The Ascent Church

Addition and Remodel

Site Development Plan

PCD File # PPR265

1 SDP - SITE PLAN & PARKING PLAN
1" = 50'-0"

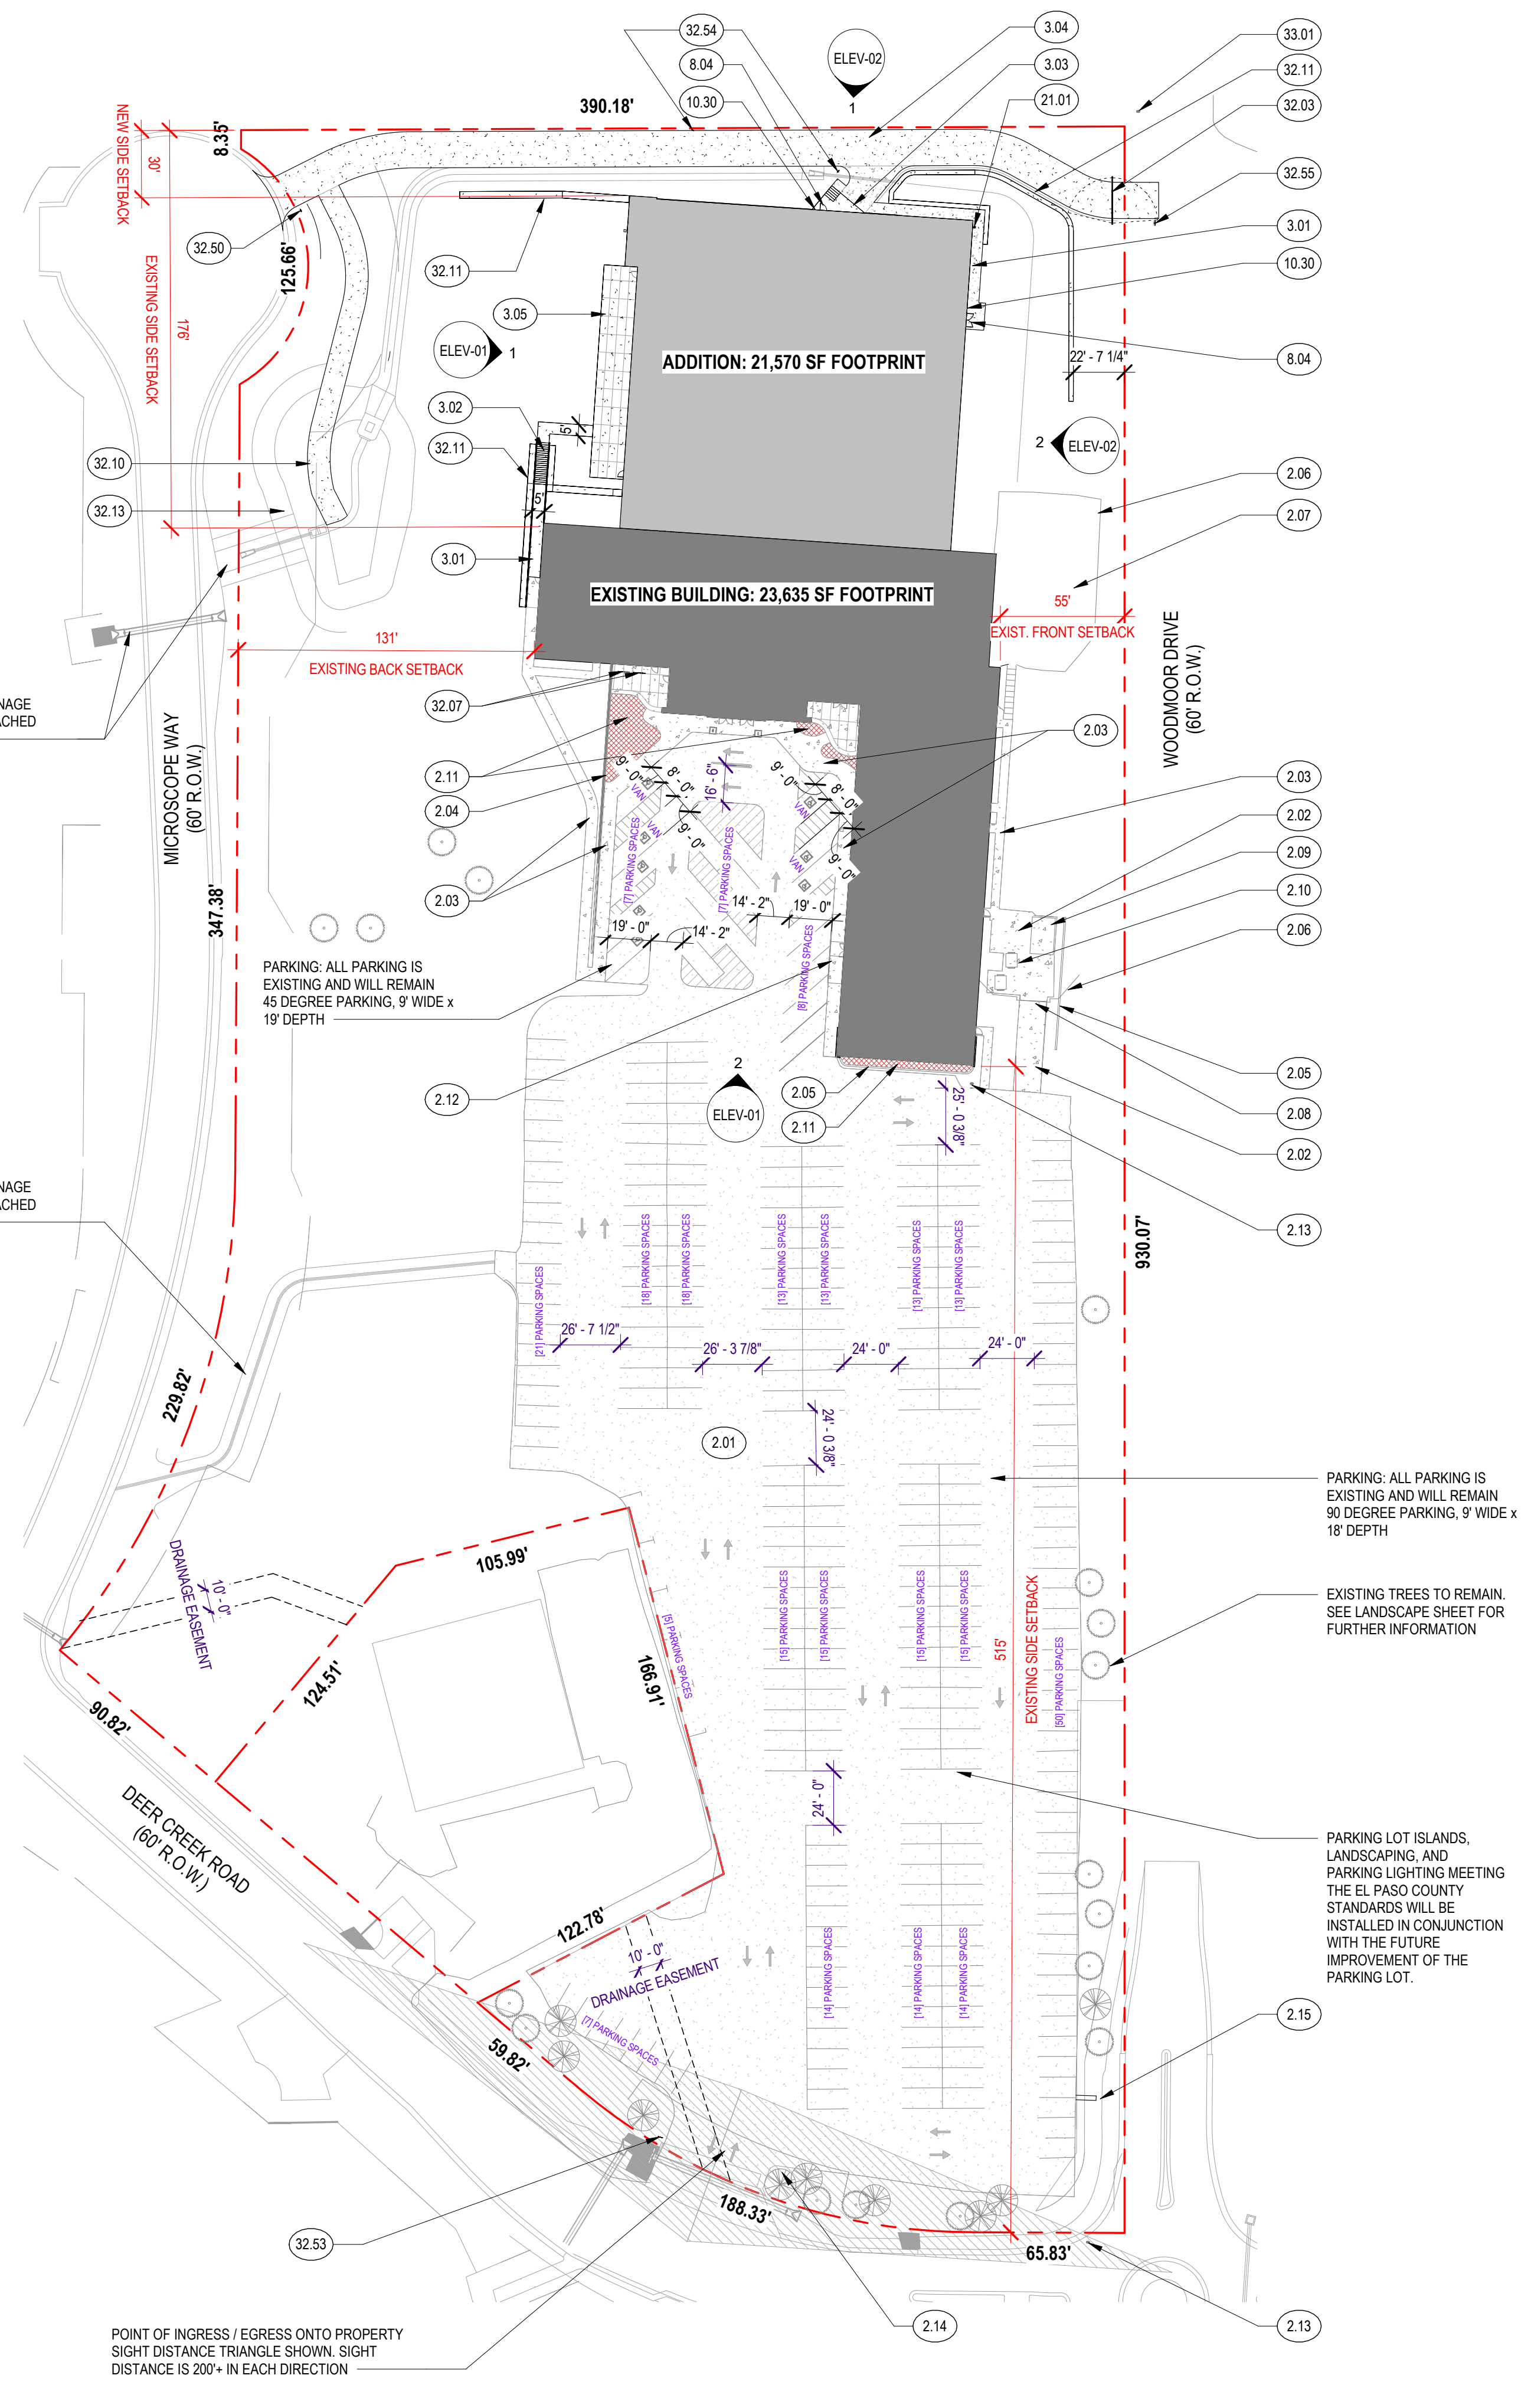
See P91009 in EDARP for the Site Dev Plan approved for this site in 1996. Parking lot islands and significant Woodmoor Drive roadway/land use buffer were provided at that time. As discussed during the EA Meeting, the overall landscaping/parking/lighting needs to meet current Code with this Site Dev Plan review.

new driveway access permit will be required. Understood. We understand an access permit is required and one will be applied for and obtained prior to initiation of earthwork.

Add drainage easement boundary around detention pond and label

depict a drainage easement to ROW Drainage updated and shown. Easement shown on attached civil sheets.

6) There shall be no direct vehicular access to Woodmoor Drv. Please note that public access will not be allowed, potentially include "Fire Access Only" signage?

Identify the wall's distance from the property line and height.

Call out retaining wall elevations Civil Plan was not included

Discussed with EPC and it was agreed that parking improvements, landscape, and lighting can be installed in conjunction with the future improvement of the parking lot, which is the next phase in the overall project. A note stating this has been added to the plan.

Drainage updated and shown. Easement shown on attached civil sheets.

Do not enter sign added at each end and will include "fire access only". See keynote 32.50.

Civil sheets have been included and show wall heights.

2 SDP - EXT ELEV - SOUTH ELEVATION
 3/32" = 1'-0"

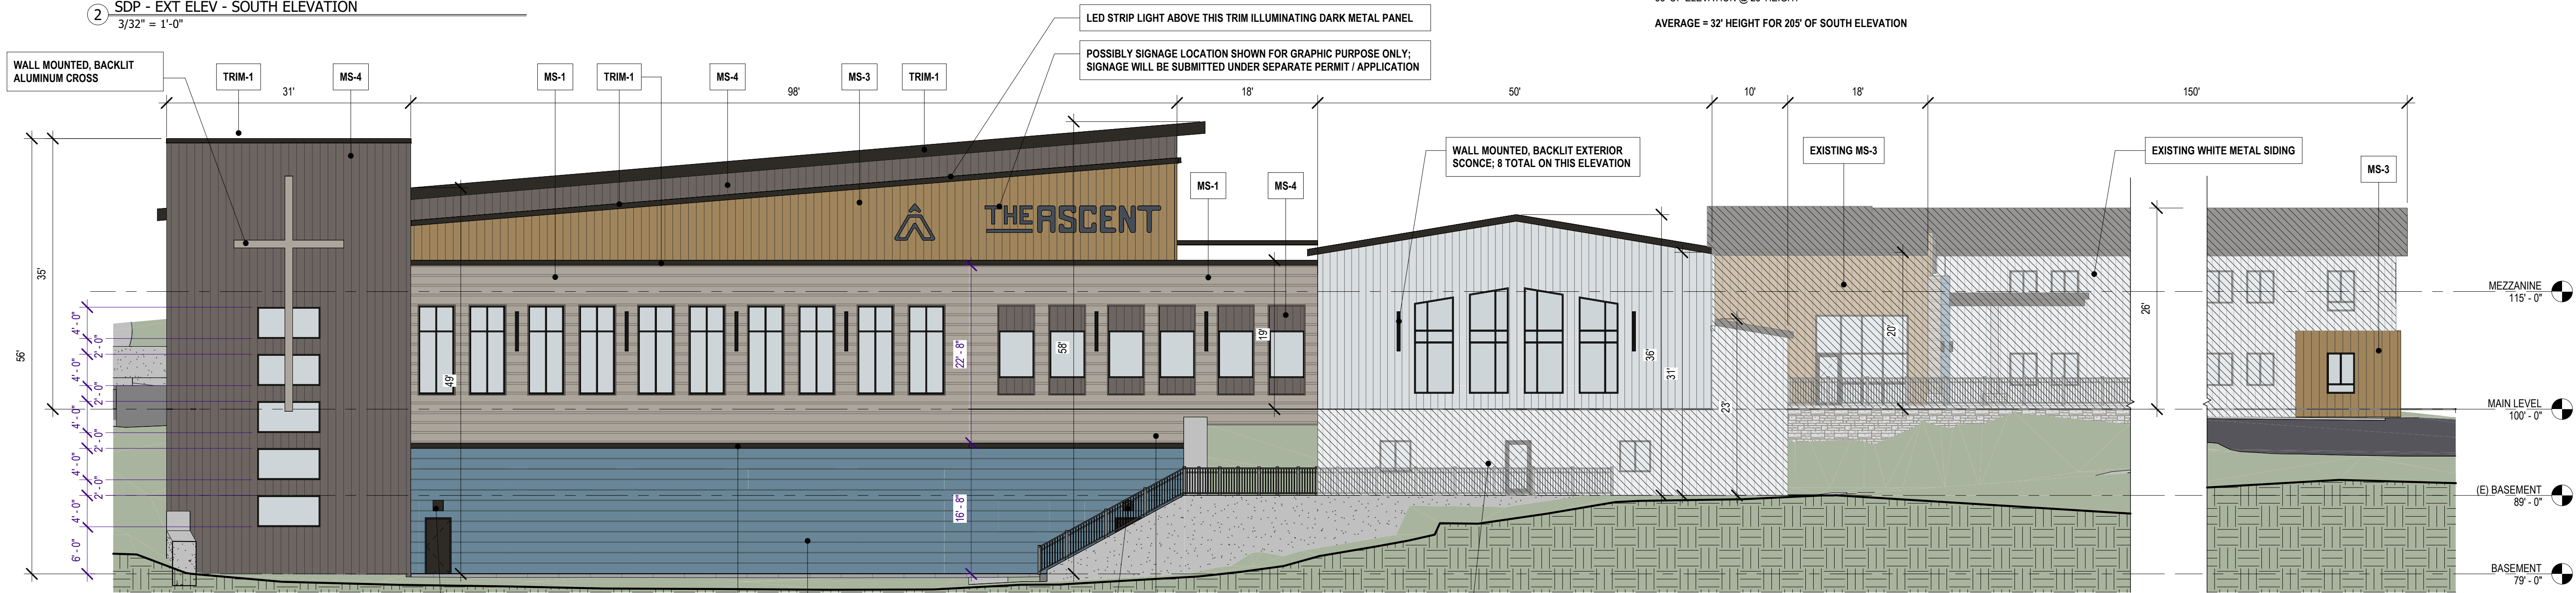
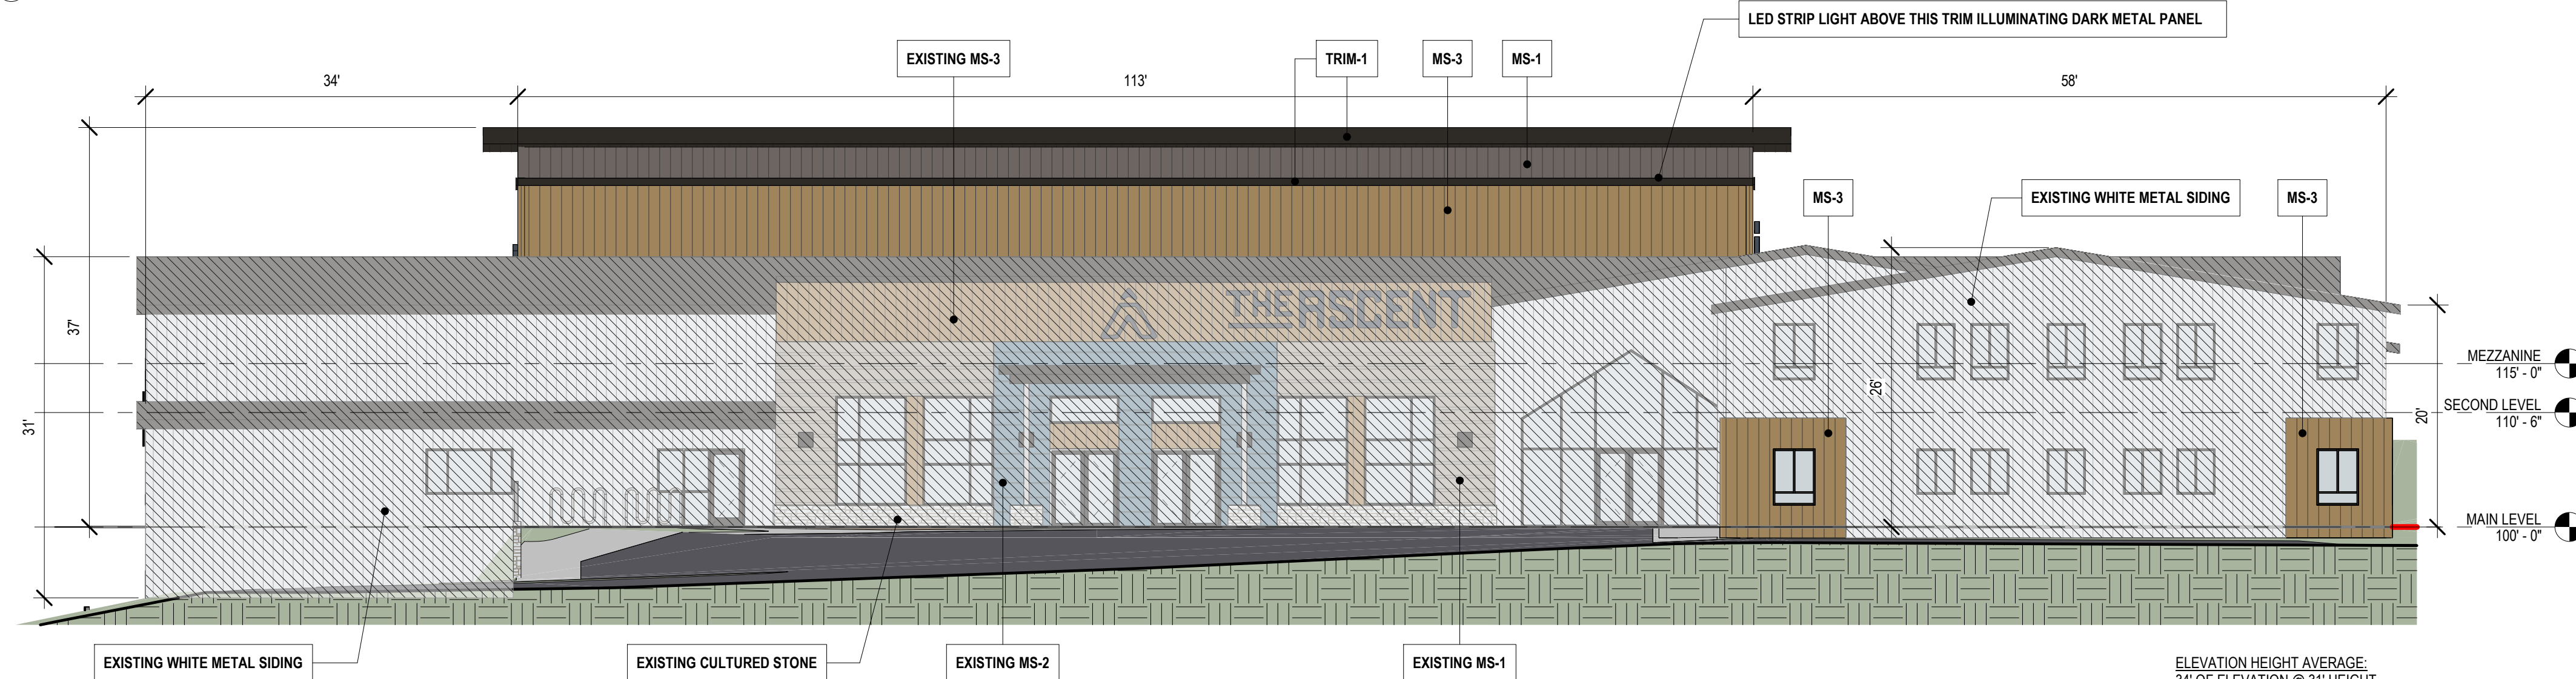
The building addition appears to exceed the maximum height in the A-5 zoning district -- (this was discussed with and confirmed by Team Lead and Planning Manager)

A Religious Institution is not exempt from the maximum structure height of the zoning district (30 ft) as measured by Ch 1 (below). As you can see below, the average of all averages is not the method of measurement. If the structure is 30'-36', Administrative Relief may be requested. Anything over 36' will need Board of Adjustment (BOCC) approval.

Discussed with EPC and agreed to using the calculations provided to identify the tallest average height at 36'. An administrative relief will be submitted. Max. average height has been added to sheet.
